Application for Planning Permission

Development: Proposed single storey flat roof extension to the rear of exsisting AGC, including installation of external associated a/c plant and smoking shelter to existing yard area.

Location: 32 London Road Bognor Regis PO21 1PY

SCALES 1:50 @ A1	CHECKED
SHEET NUMBER 3635(B)02	
REVISION	
DATE 30/09/2026	DRAWN S.STEEL

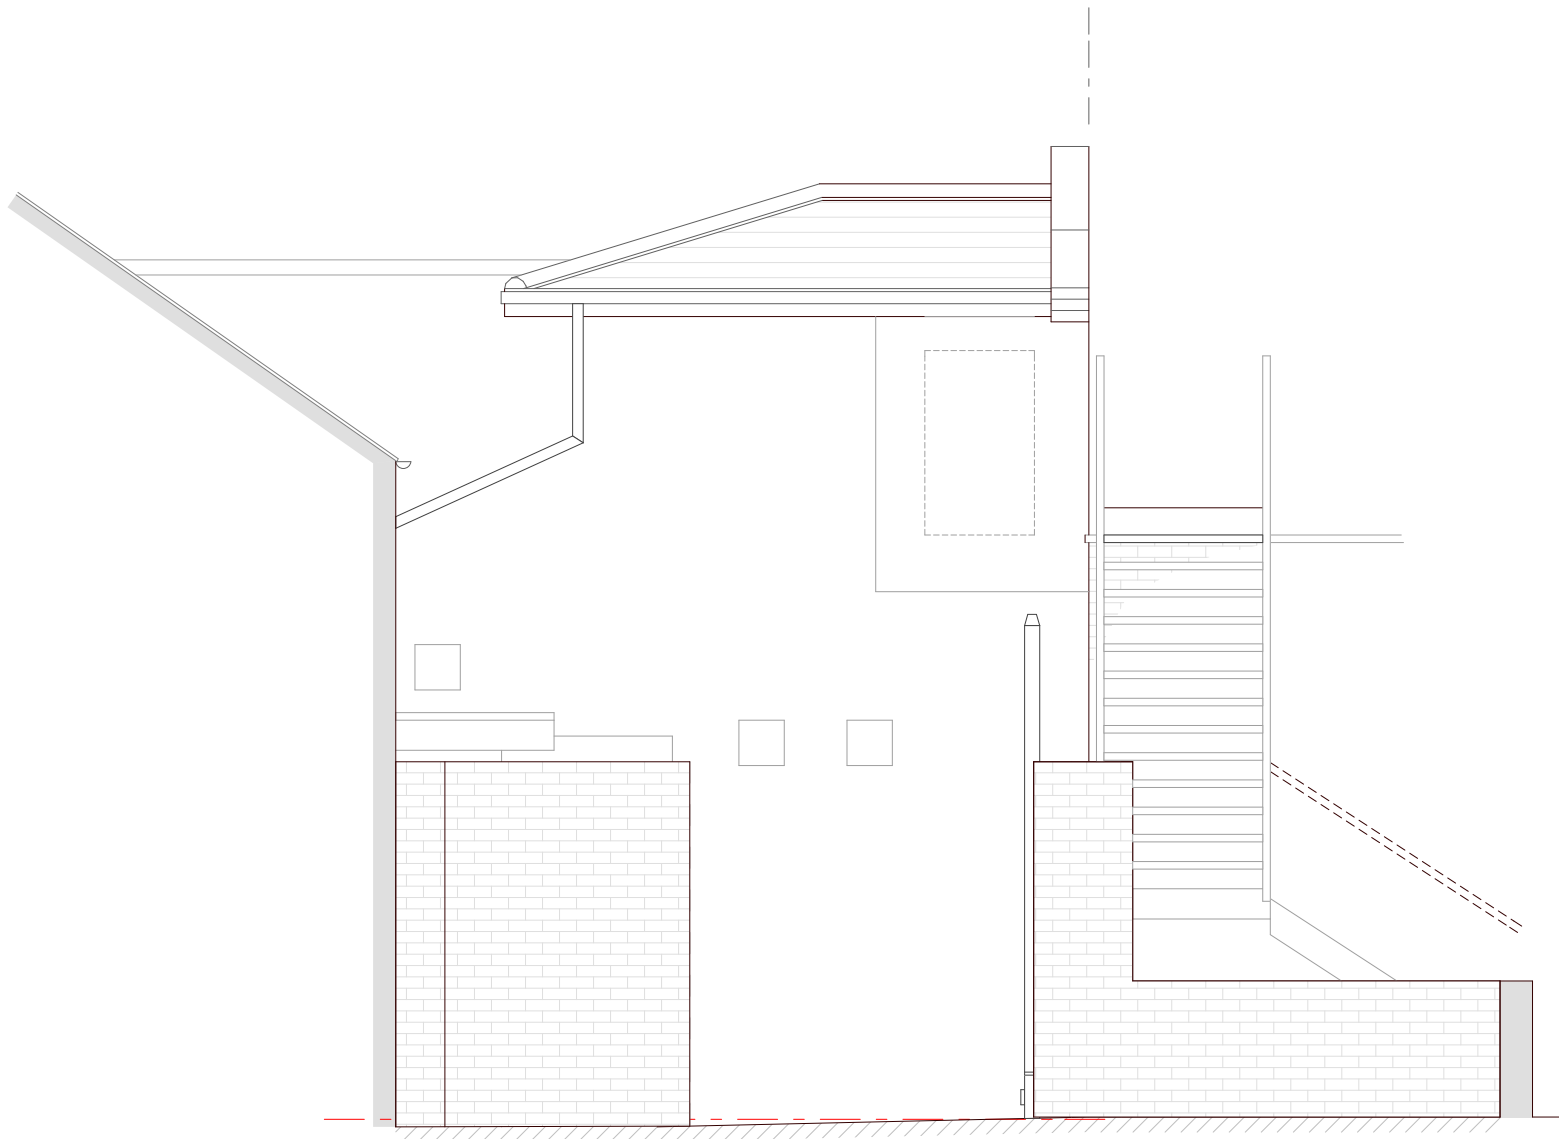
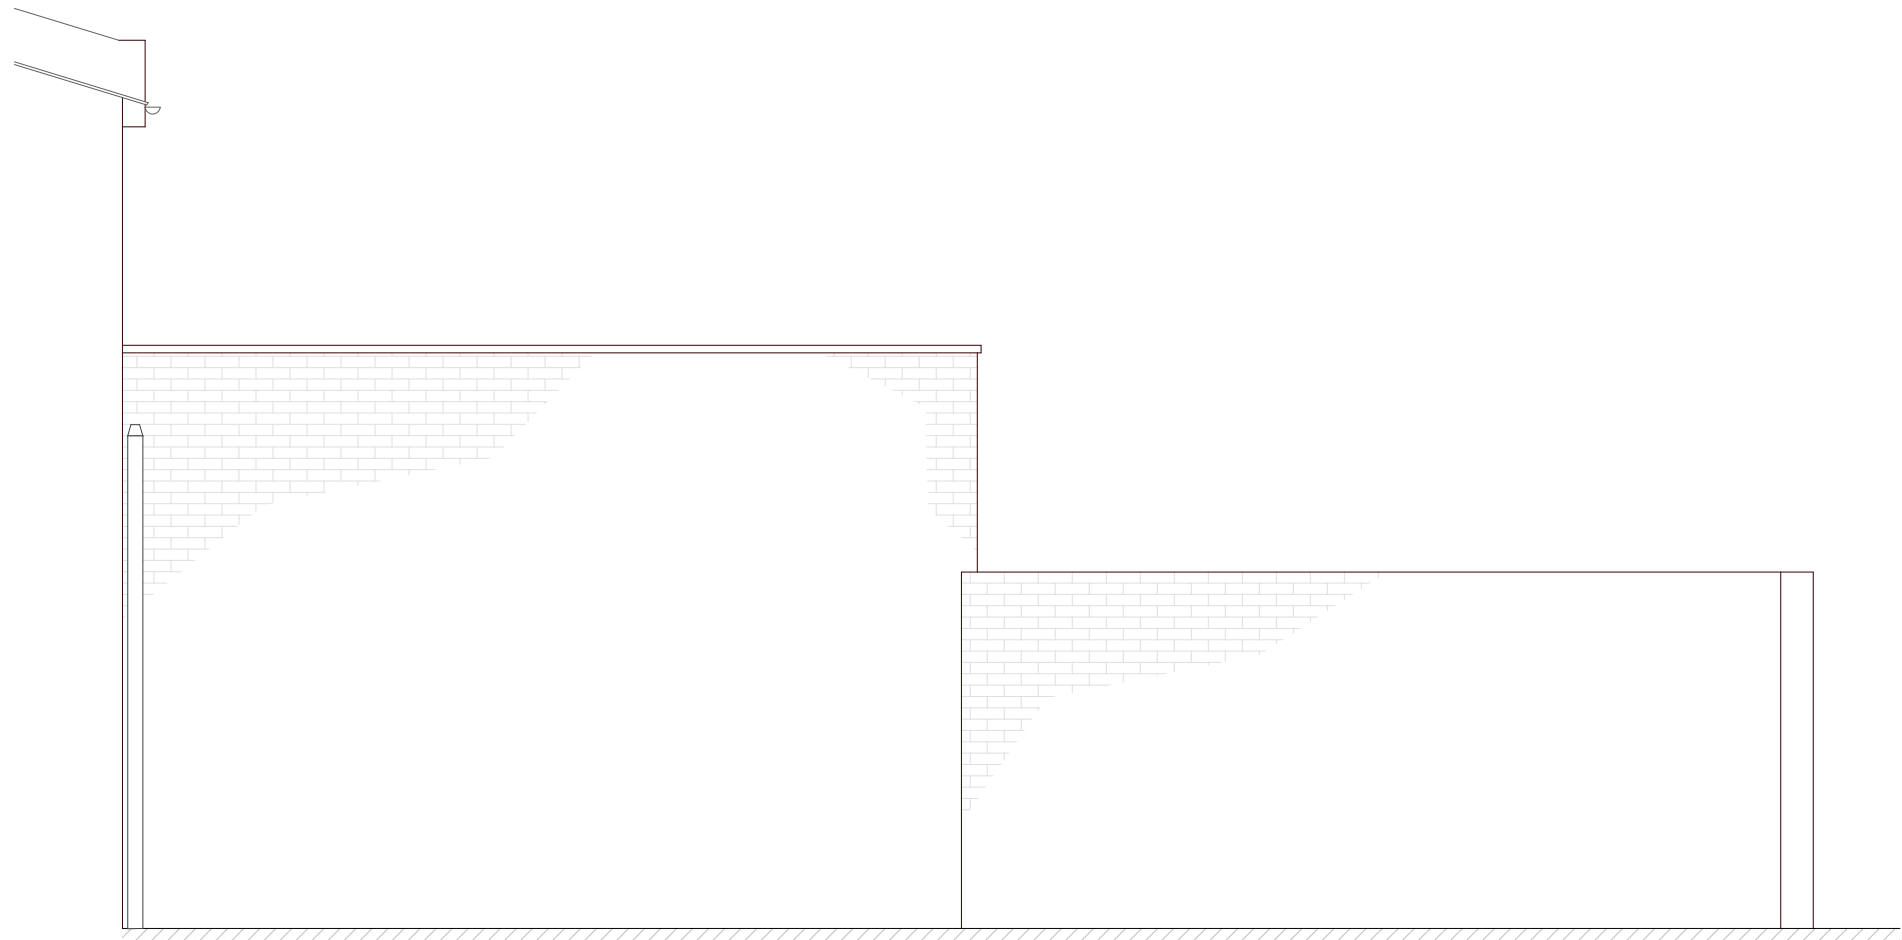
There appear to be 2 x 'West' labels, please amend to show 'East' and 'West'

SHEET NUMBER
3635(C)02

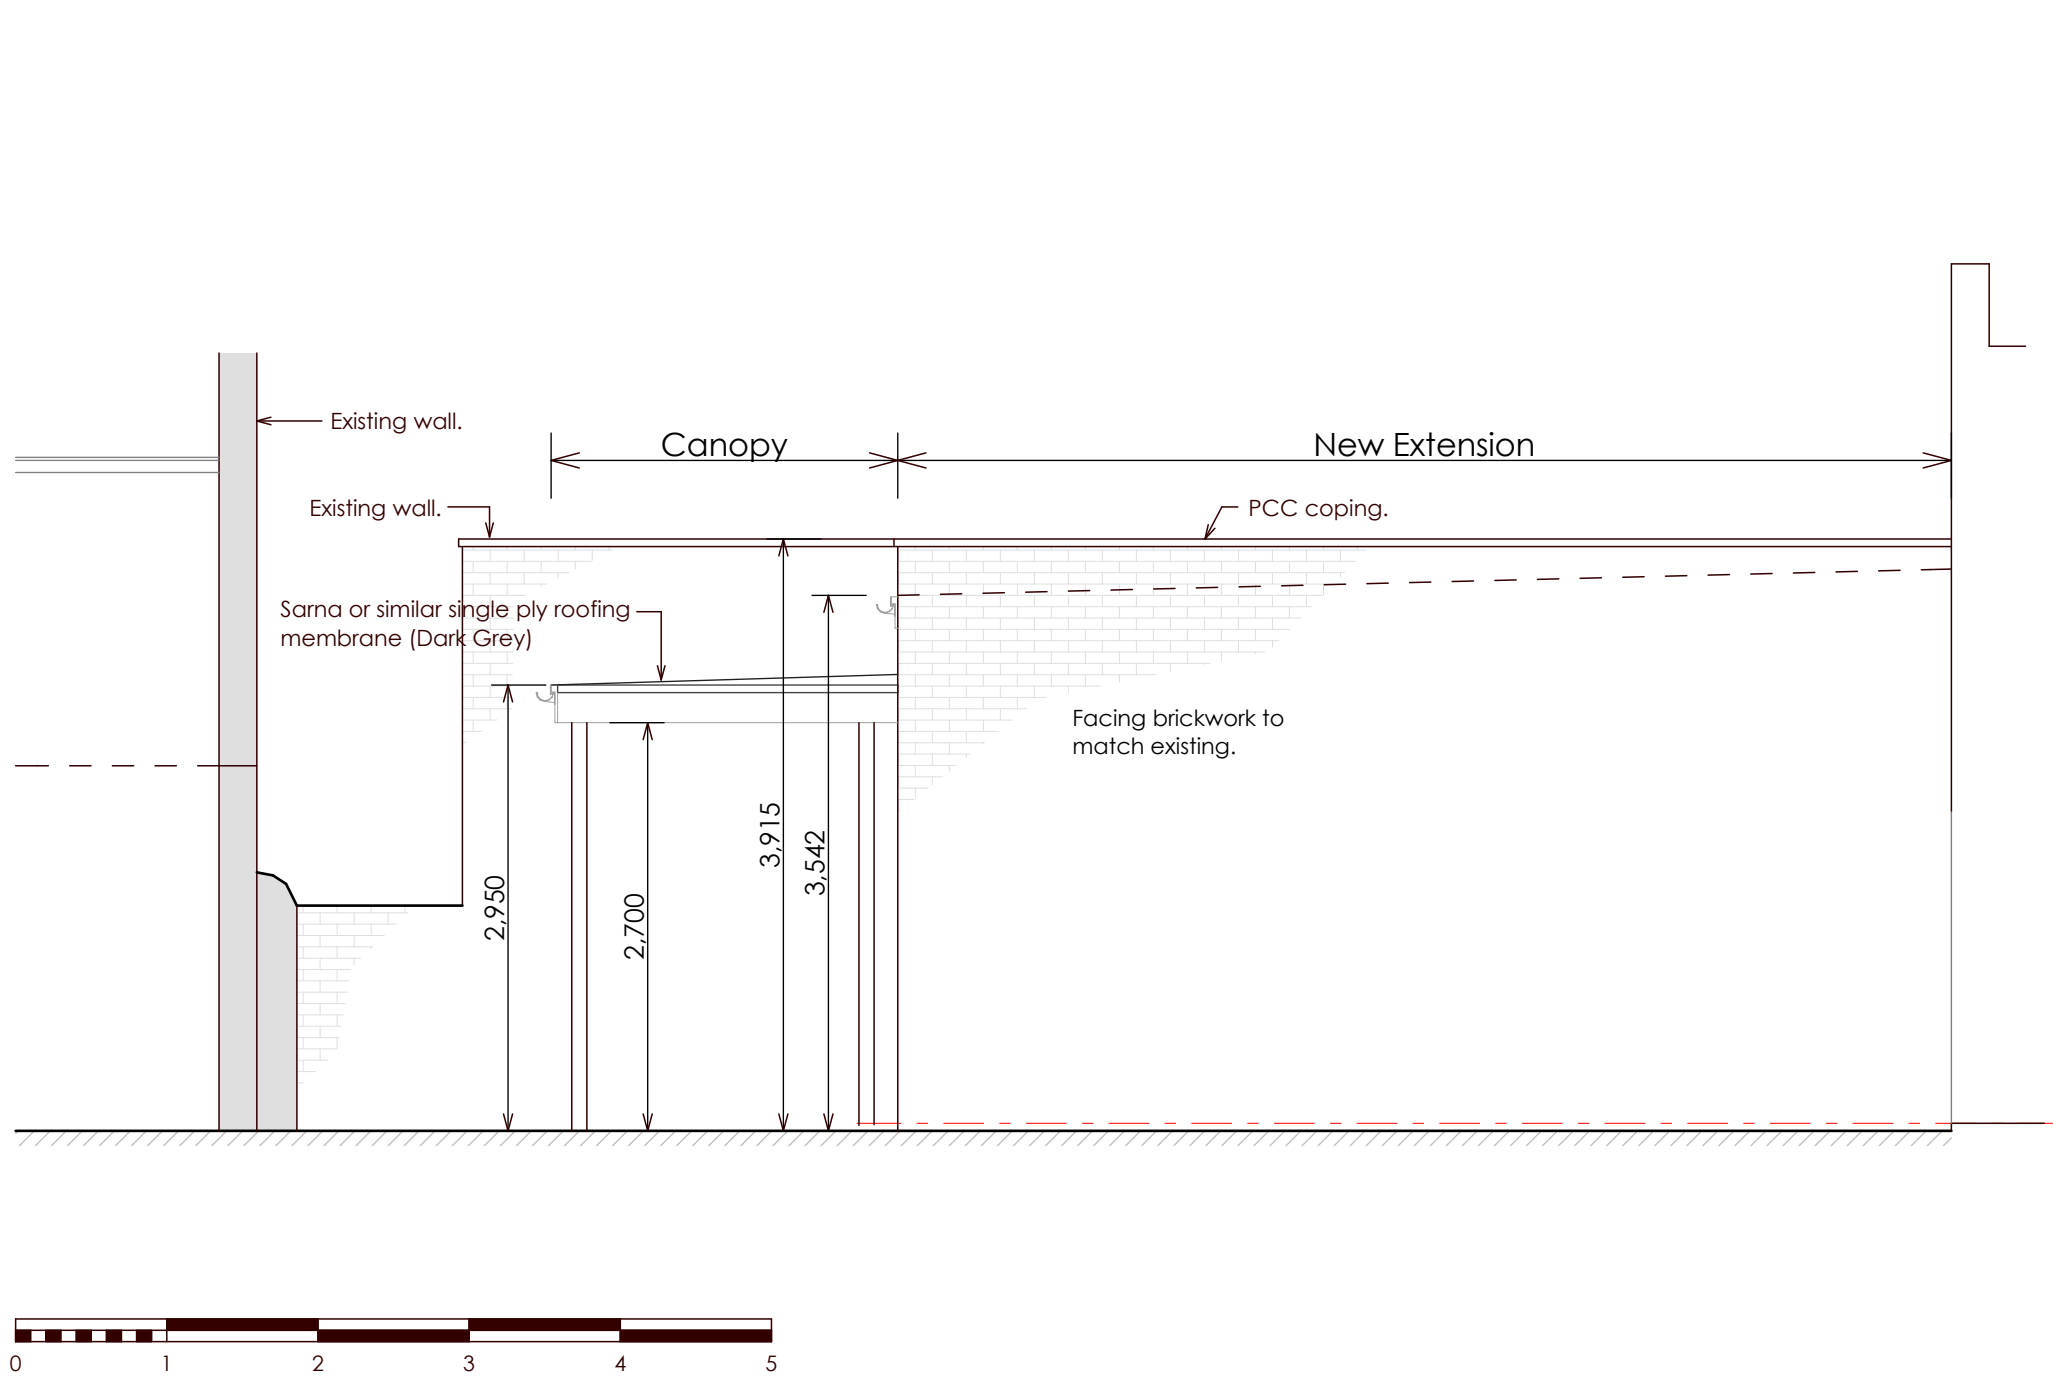
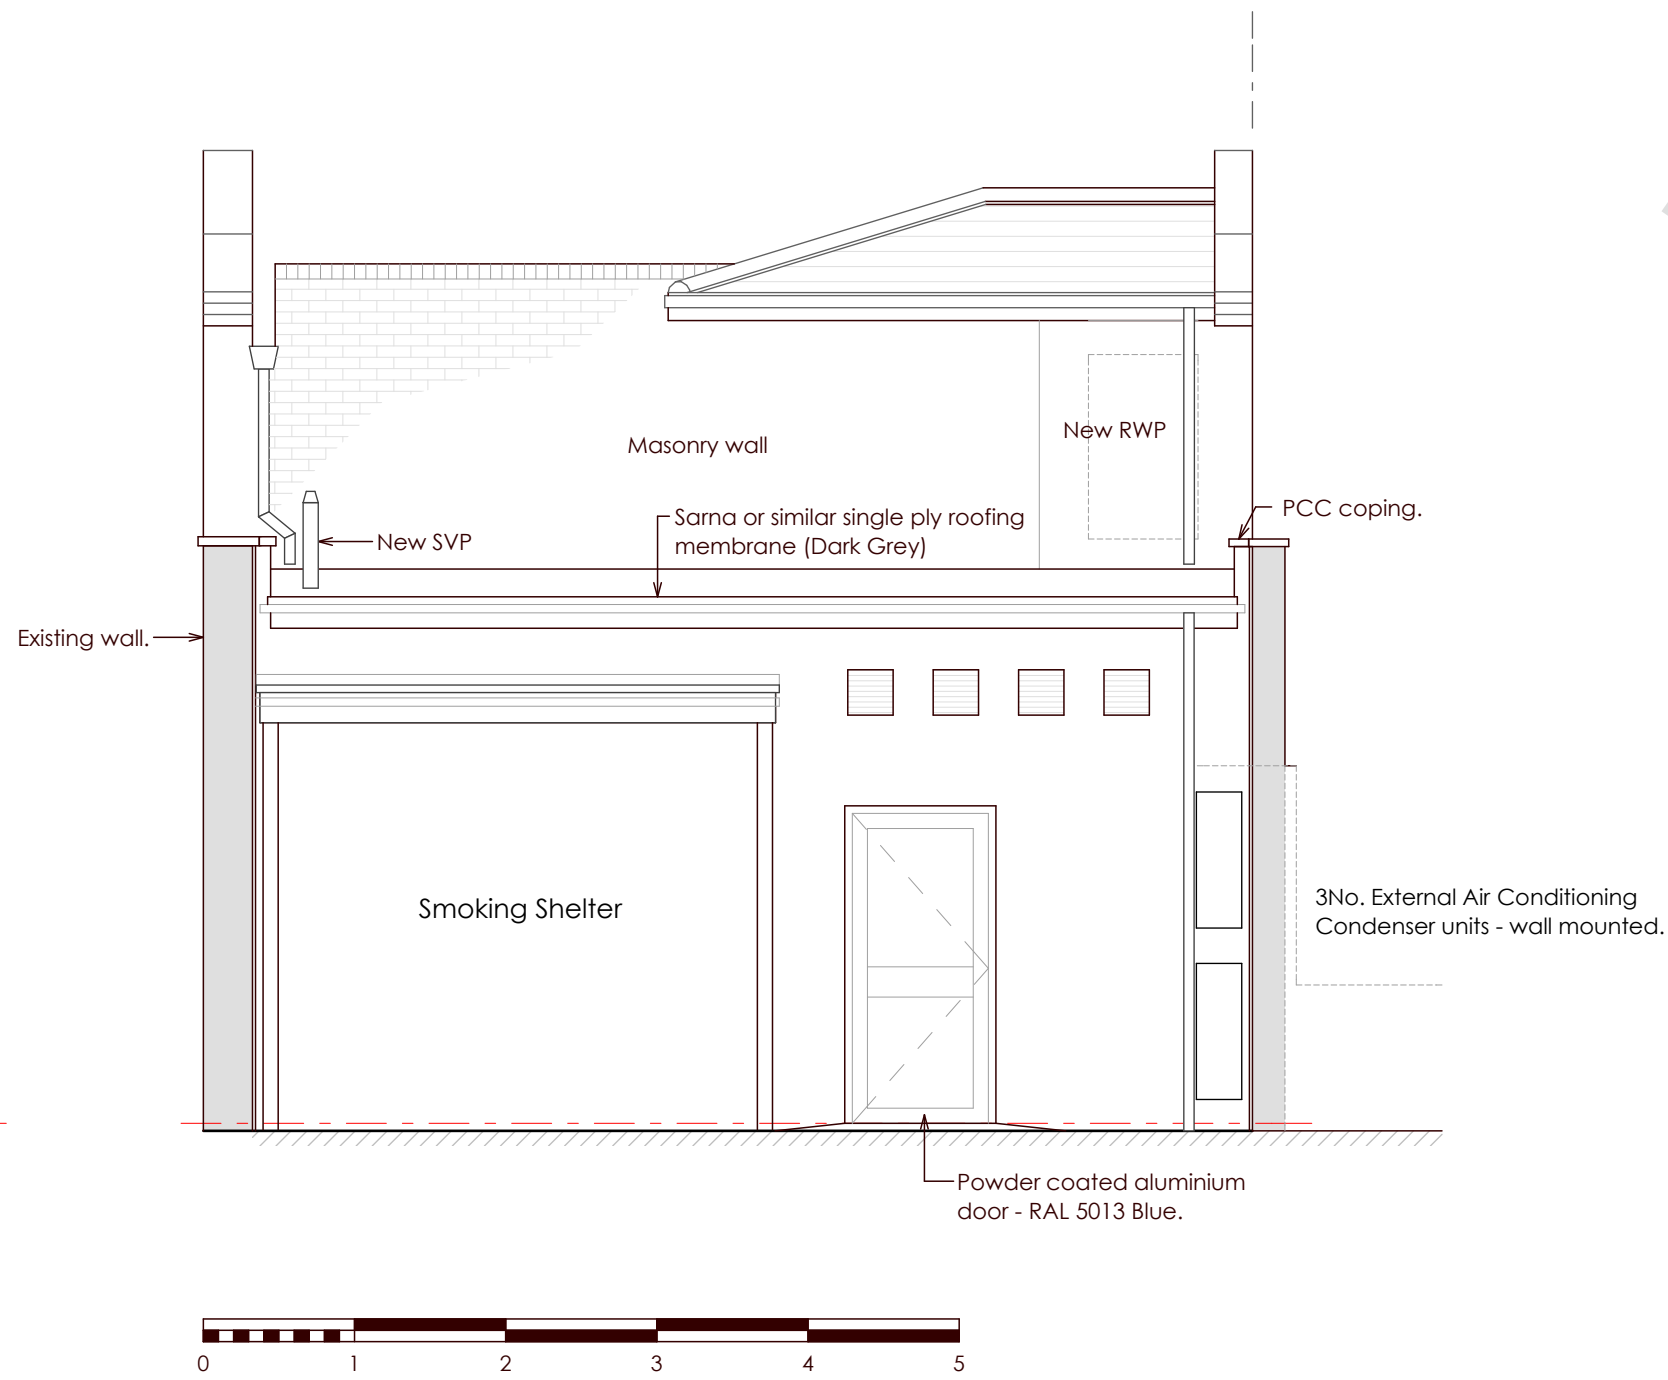
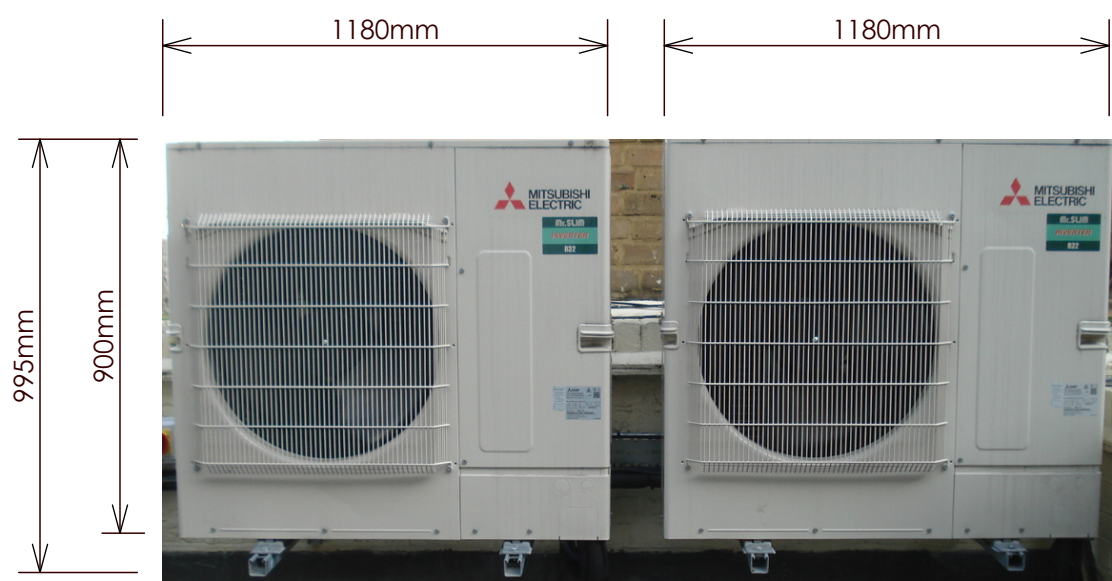
The condensing units are not scaling at 1:50 please amend to show correct scale.
